Re: **Double Eagle II Airport Aircraft Hangar (Tri-Motor)**
Grading and Drainage Plan for Grading, Paving, and Building Permits
Engineer's Stamp dated 7-15-08

RE: Double Eagle II Airport Aircraft Hangar
Grading & Drainage Plan for Grading, Paving
and Building Permits
(E06/D001A)

Re: Double Eagle II Airport Aircraft Hangar (Tri-Motor)
Grading and Drainage Plan for Grading, Paving, and Building Permits
Engineer's Stamp dated 4-10-08 (E06/D001A)

C-102

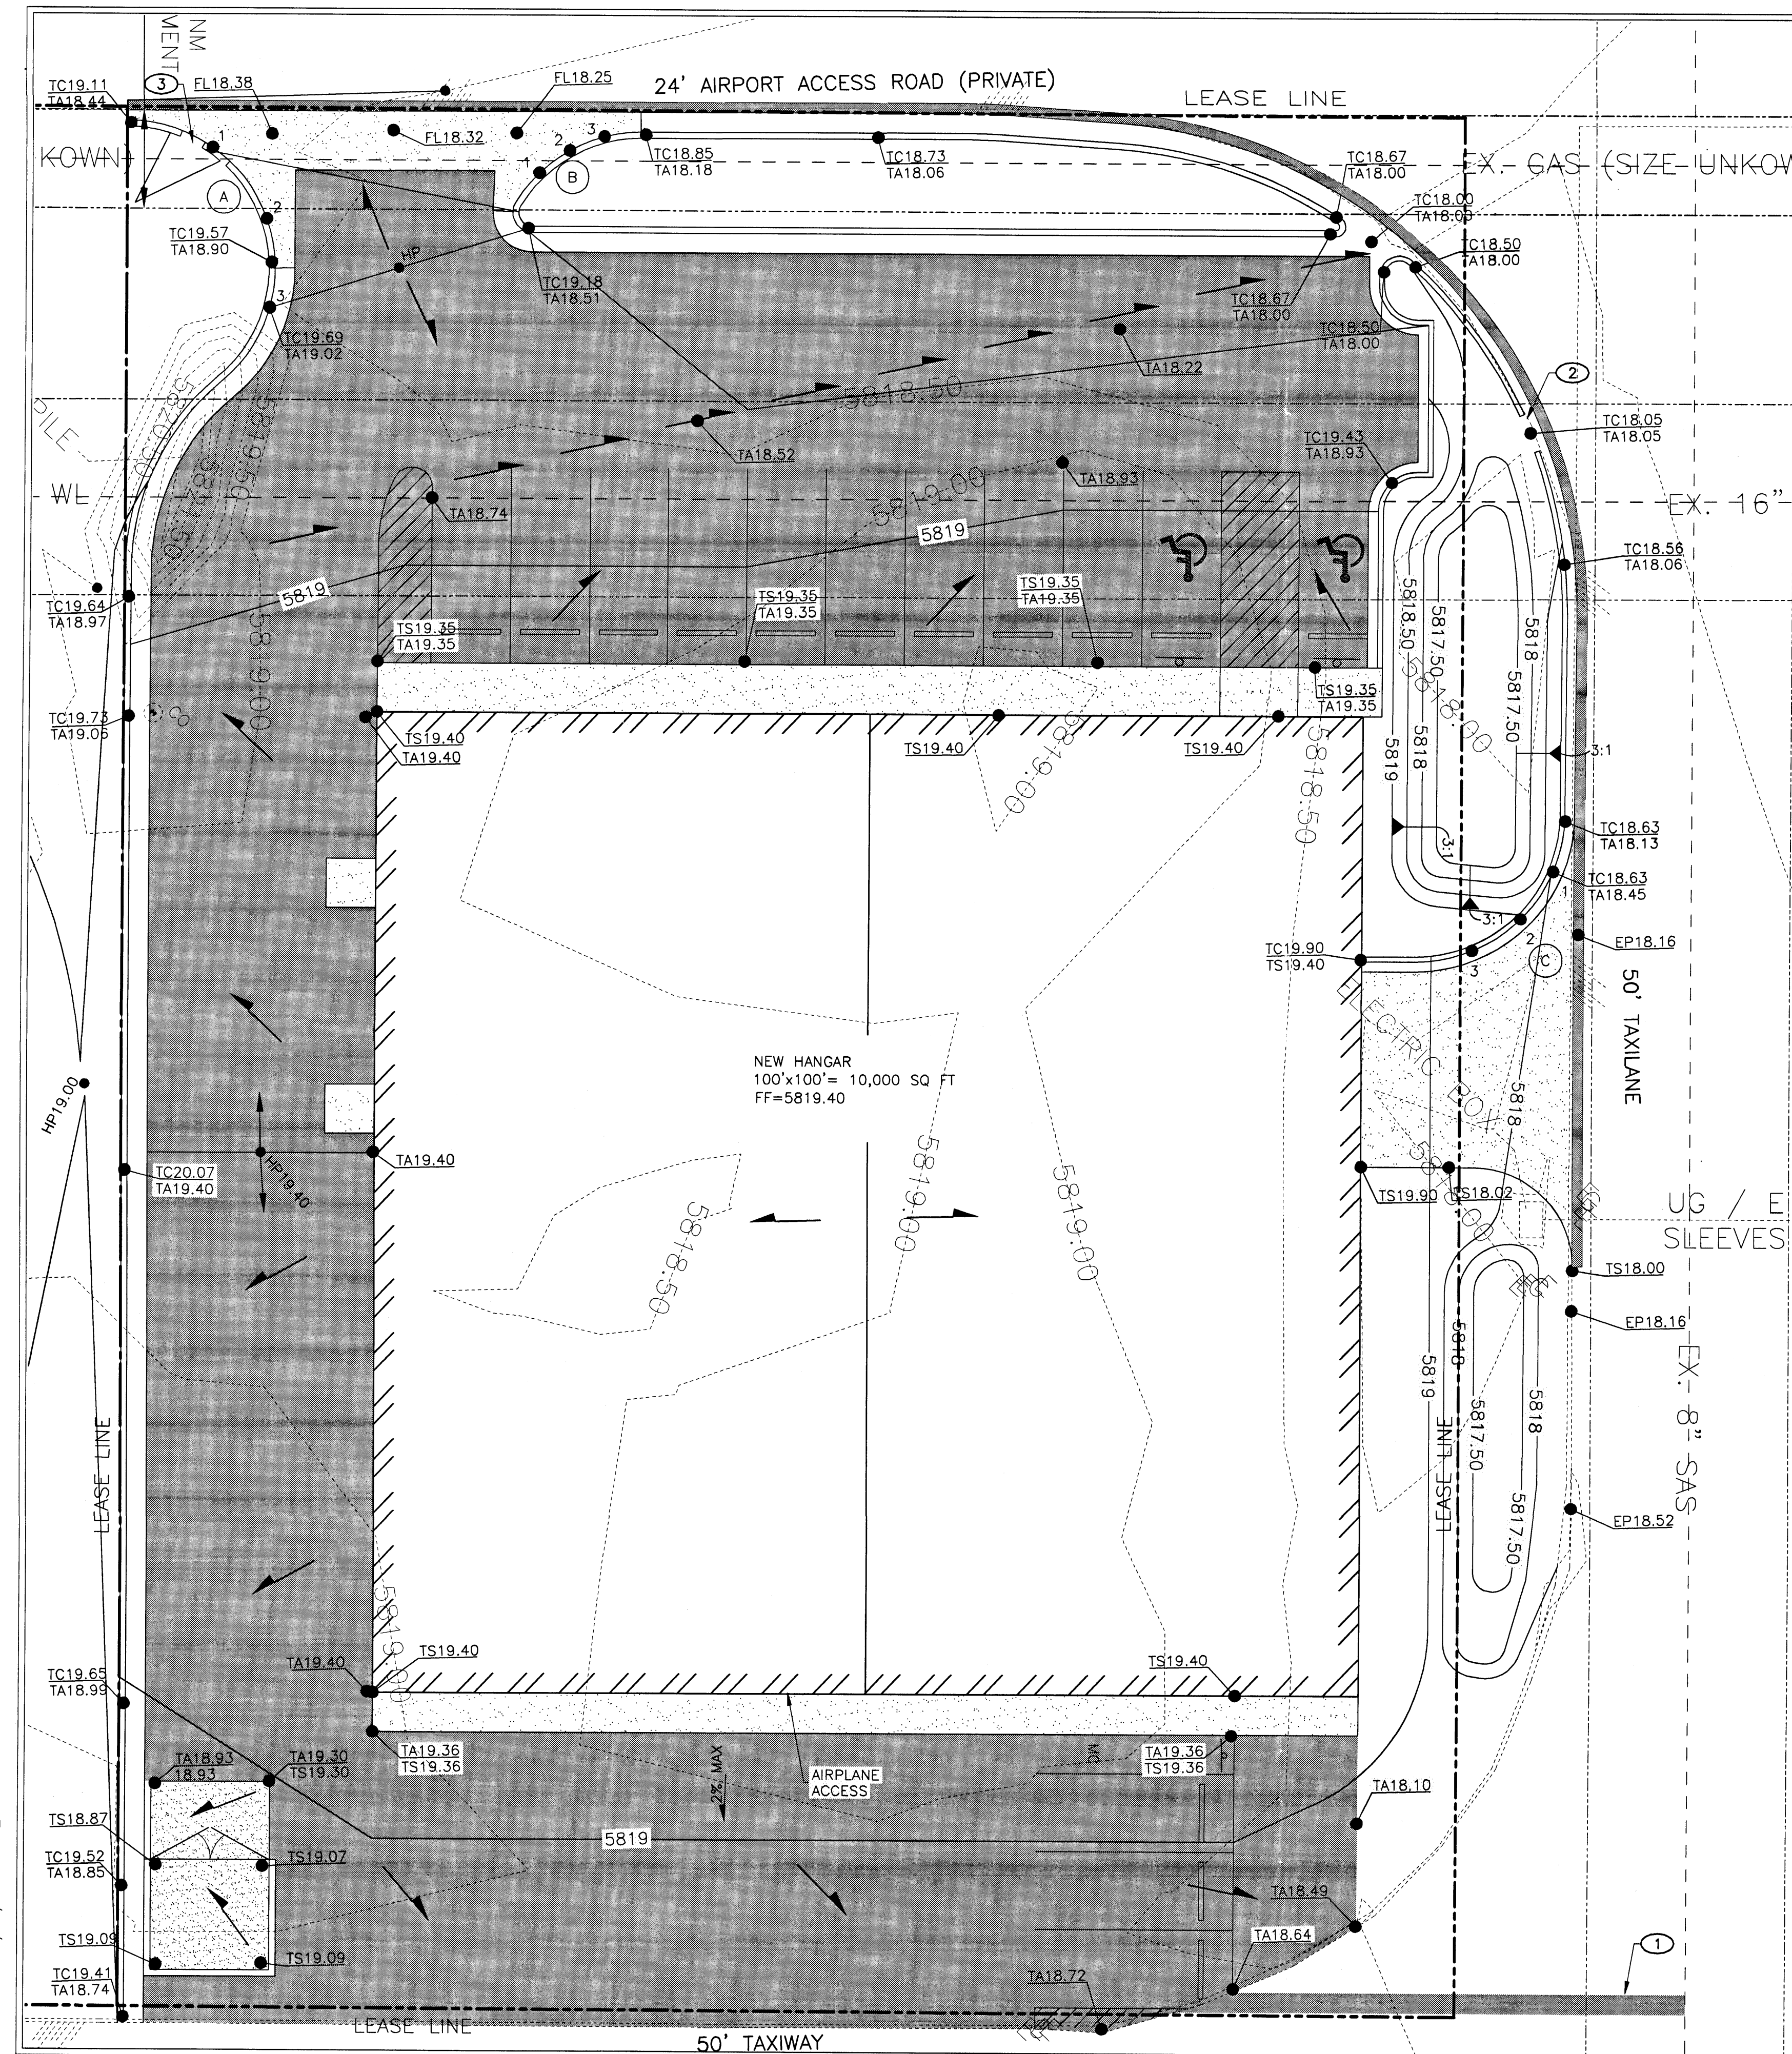
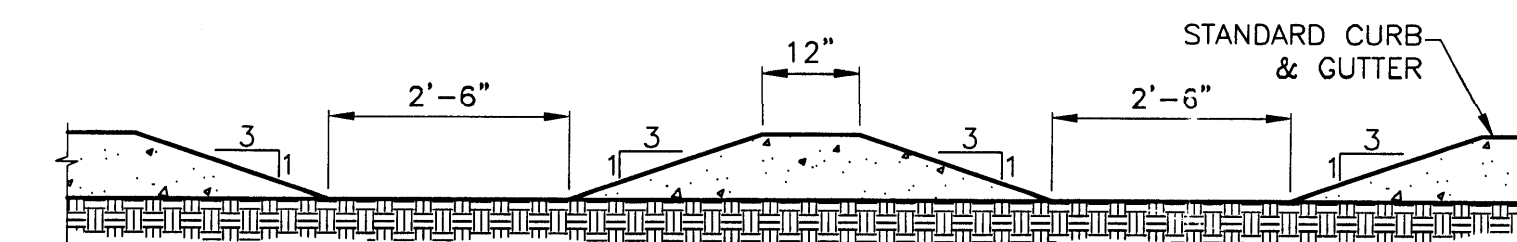
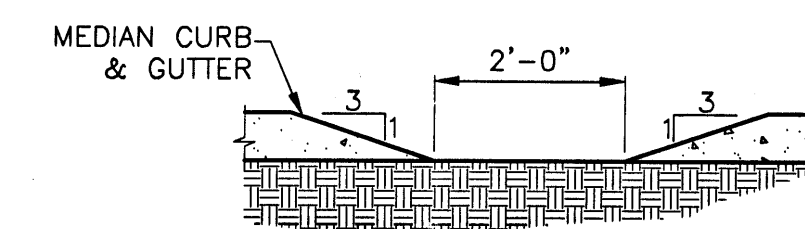
COA Comment: *"Our previous review indicated that the building FF elevation needed to be raised to ensure that drainage flows will not reach FF elevation. This submittal actually lowered the FF grade. I acknowledge your constraint with existing elevations on the taxiway and the need to keep the maximum slope on paving and ramps to the hangar at 2%. However, I am concerned that there may still be opportunity for flows from the west to enter the site and cross the parking lot toward the building which has no curb or other obstruction to divert flows northerly toward the pond".*

COA Comment: *"You stated in your reply letter that the 12" line entering the north pond below the outlet pipe invert will result in some water being retained in that pond. Clearly indicate this intent on the plan."*

COA Comment: *"The 12" PE Storm Drain line on site is too shallow to meet the manufacturer's minimum cover requirements. Lowering the inverts will alter the drainage plan, and may cause grade conflicts with the existing water line on the NE side of the building. This whole system needs to be reviewed".*

COA Comment: *"To facilitate evaluation of this design, the plan for the south eastern side of the parcel needs to provide contours and spot elevations, not just say "Match Existing". Also, label if this is existing asphalt taxiway, and provide enough offsite grade information to reflect whether any flows will enter or bypass this site".*

MCA Response: The Finish Floor Elevation was raised to 5819.40. This allowed positive drainage, varying between 0.75% and 4%, to surface flow across the parking lot into the Taxilane and Taxiway. See Sheet C-102.

MCA Response: The site was regraded to eliminate the 12" storm drain. All drainage will surface flow across the parking lot. As previously stated any ponding will be for water harvesting purposes. See Sheet C-102.

MCA Response: As previously stated the entire site was regraded to allow all drainage to surface flow, eliminating the need for the HDPE storm drain pipe and inlet. See Sheet C-102.

MCA Response: Existing "tie in" spot elevations have been provided. Curb & gutter will be installed on the NW (median) and SW (standard) sides of the site to allow offsite drainage to bypass site. See Sheet C-102.

C-103

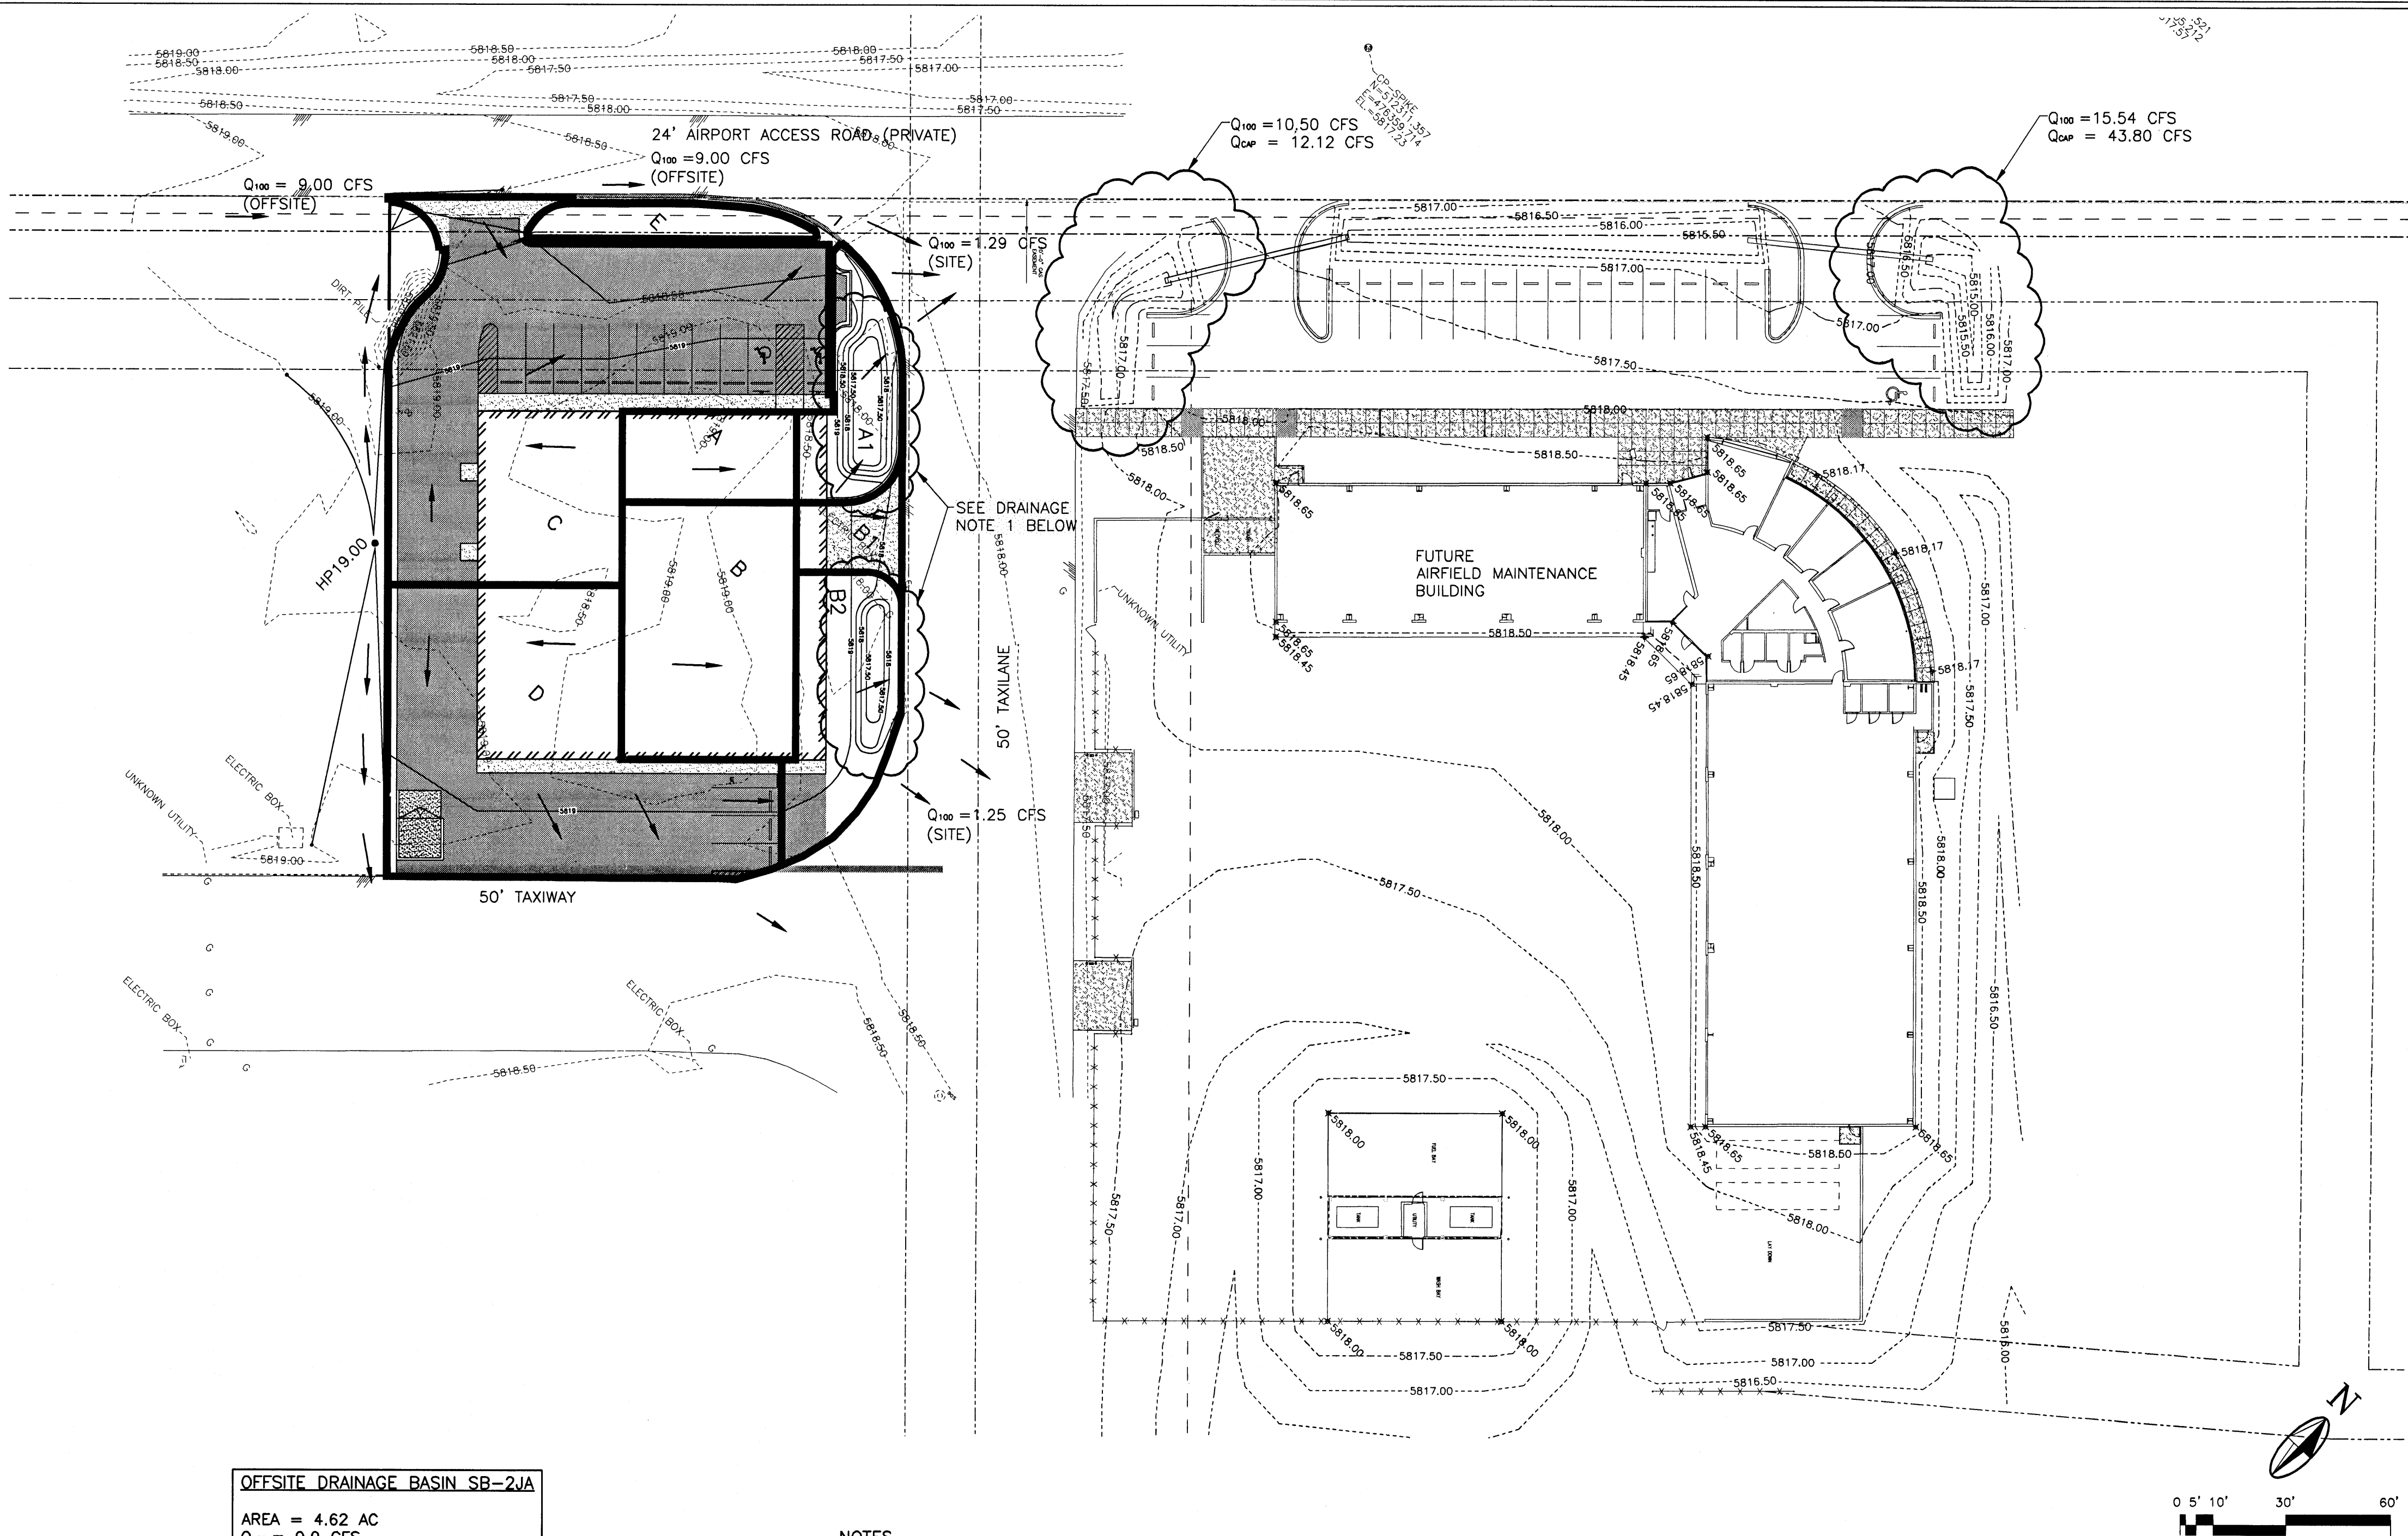
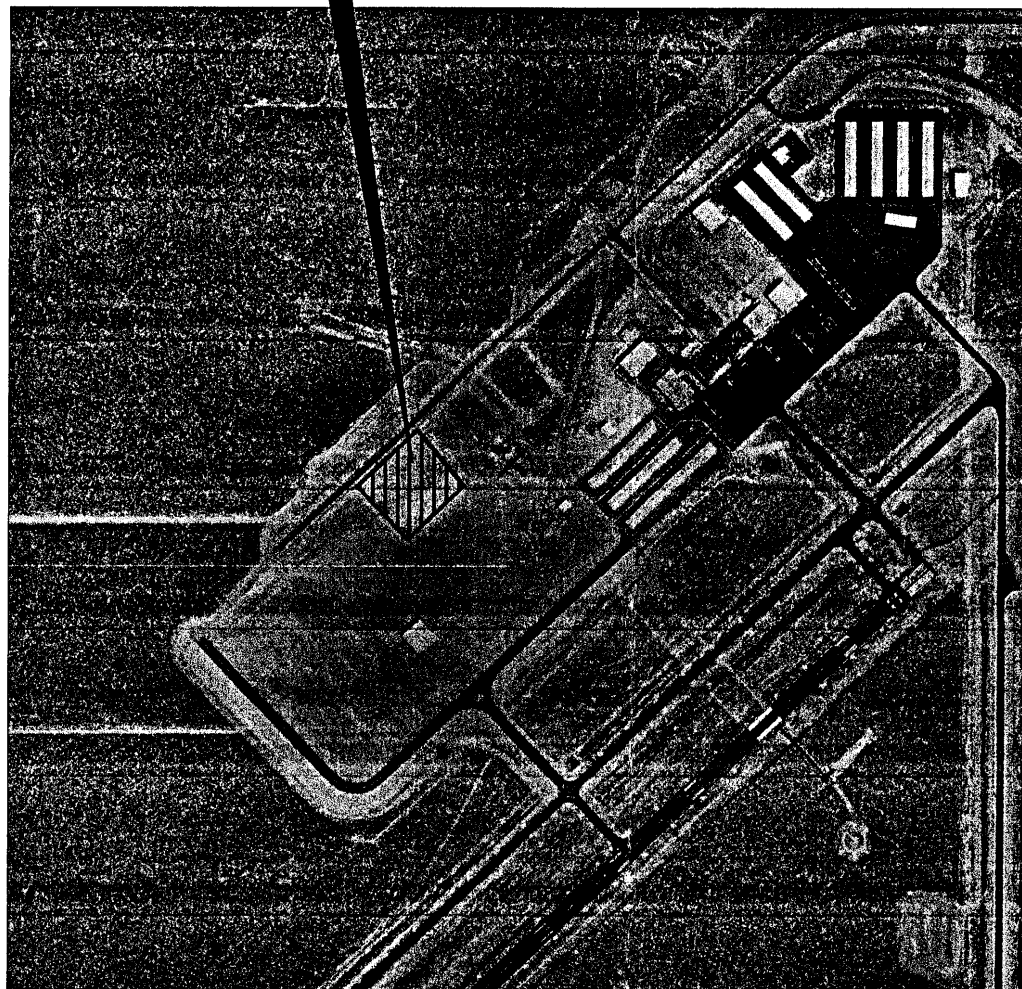
COA Comment: *"The 12" RCP outlet pipe crossing the taxiway will have less than 12" of cover below the top of pavement on the taxiway. Verify that this is adequate and/or specify any special pipe type or bedding needed to allow this condition".*

MCA Response: As previously stated, the site was regraded to allow all drainage to surface flow, eliminating the need for the 12" RCP outlet pipe crossing the Taxiway. The drainage will now surface flow across the Taxiway as allowed by the DEII DMP. See sheets C-102 thru C-103A.
